**RE: NW Bicester: Hawkwell Village: Outline application (with all matters reserved except for Access) for a mixed use development of up to 3,100 dwellings, local centre, employment areas, schools, green infrastructure and associated infrastructure (reference 21/04275/OUT)**

1. This document is prepared on behalf of Bucknell Parish Council in response to the further submissions dated the 24<sup>th</sup> March 2023 made by David Lock and Associates on the behalf of the developer Applicants (hereafter referred to as “The Applicants” or the “developer”) and the various new material recently produced in support of the application which has been submitted by the Applicants throughout February, March and April 2023, with the latest technical documents in support being served as late as the 18<sup>th</sup> and 19<sup>th</sup> April 2023.

Appendix F: Drawing 20300_SK_T_011_P1

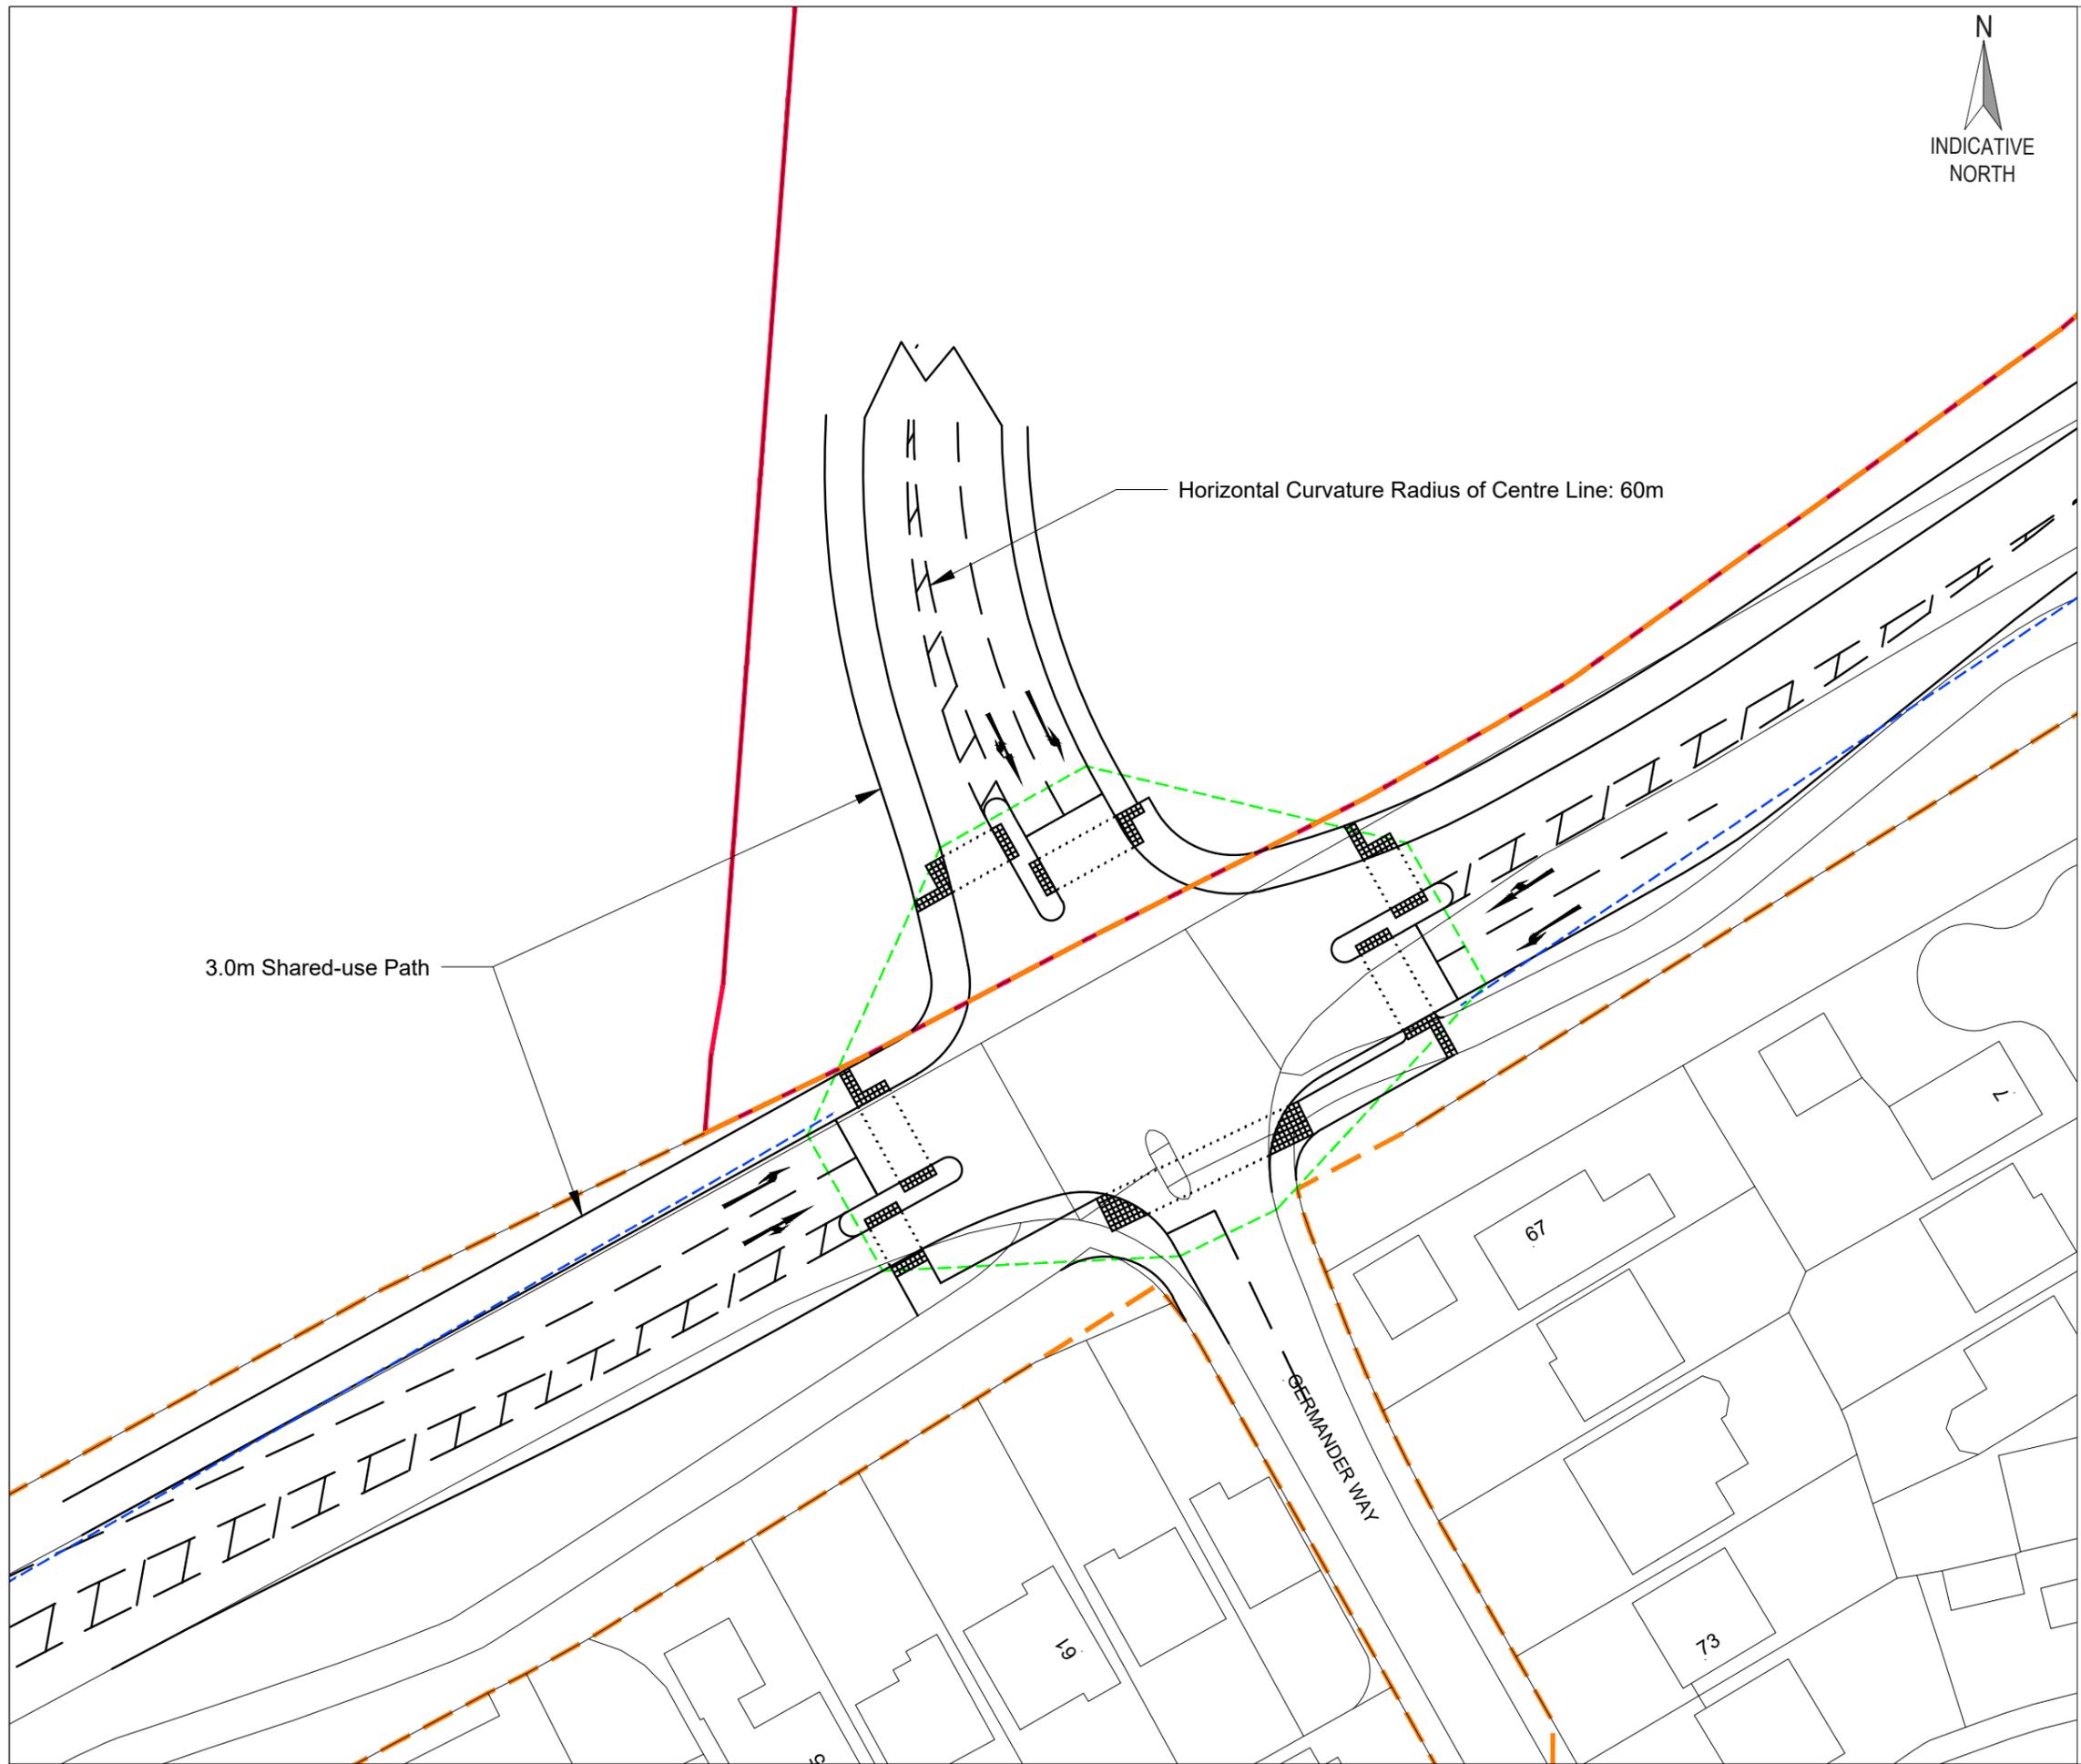
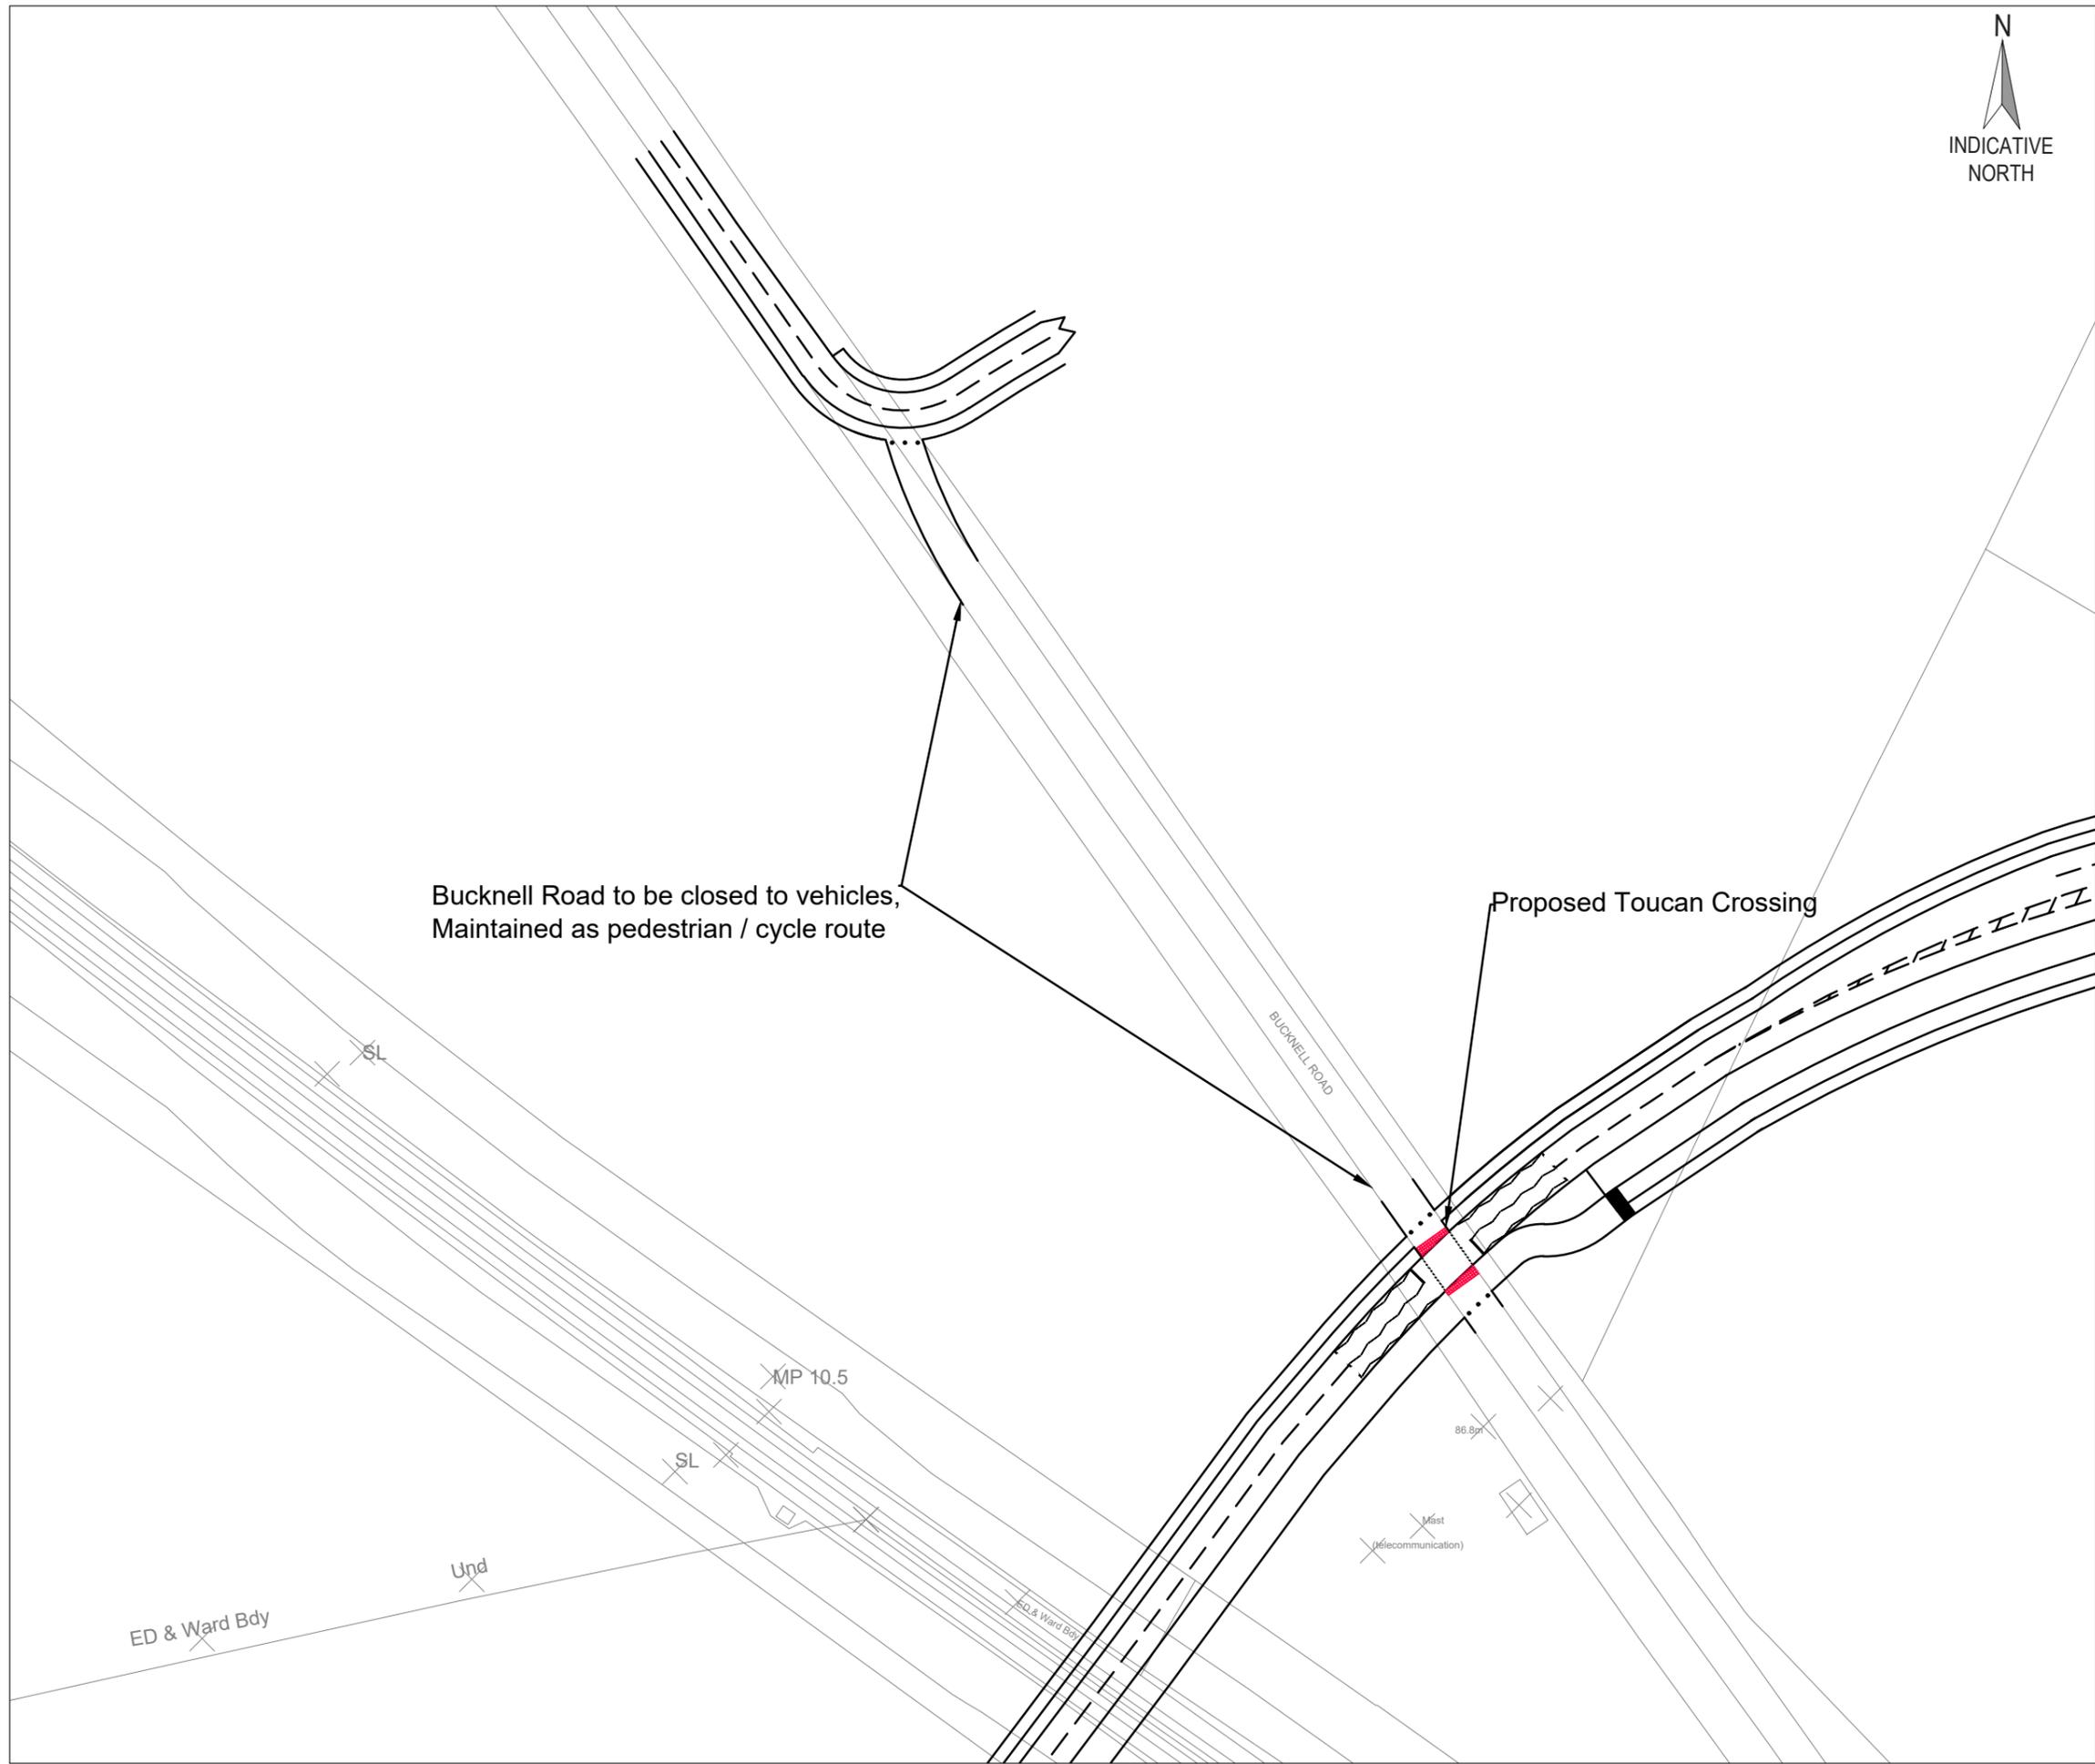
25. Unfortunately, the “interim solution” which is the subject of many of the detailed reports now produced by the Applicants, effectively consists of marginally altering the approach to the junction and replacing the current roundabout with a 4 way traffic lights system. This ‘interim solution’ is apparently being pursued in order to attempt to get planning permission granted for a site which will, on any account, not be served for the foreseeable future, by the necessary infrastructure which the entire original plan was predicated on (namely the presence of the Strategic Link Road to handle the traffic from the site), but with the agenda of allowing the Applicants to develop farm land and build housing for them to profit from, without then providing any of the other amenities, parklands, transport, etc which the overall plan relies upon.

26. The interim solution for this junction, (pictured below), would do nothing to overcome the actual problems with this junction, involving the ring road having to go under a narrow bridge before meeting an extremely tight right hand turn back on itself on the far side of the bridge:

*“OCC Highways has responded informally to the applicant through emails and in meetings, to previous iterations of this technical note. **We have indicated that we do not support this scheme** for the following reasons.*

*a) Cost: It is proposed that the scheme would allow the site to develop up to a threshold (1250 dwellings although in TN11 it is stated that it would provide **sufficient capacity for the whole development, which is not demonstrated**) It is purported that this would finance the construction of part of the realignment of the A4095. **We are concerned that this interim scheme would cost several million pounds and as an interim scheme, would also be costly to remove. This puts the ability to finance the A4095 realignment into question and could detract from the ability to deliver sustainable transport improvements.***

*b) **The deliverability of the scheme is questionable, given the very tight geometry. It relies on very precise manoeuvres by HGV drivers. Even if deliverable, it’s unlikely to deliver the predicted capacity improvements due to the constraints.** The scheme is likely to be in place for many years and could jeopardize the delivery of the cycle and pedestrian infrastructure improvements required to deliver the Bicester LCWIP.*

*c) We have had **safety concerns**, which later iterations have sought to address, but the scheme in its current form is not acceptable and **a Road Safety Audit has not yet been carried out.**”*
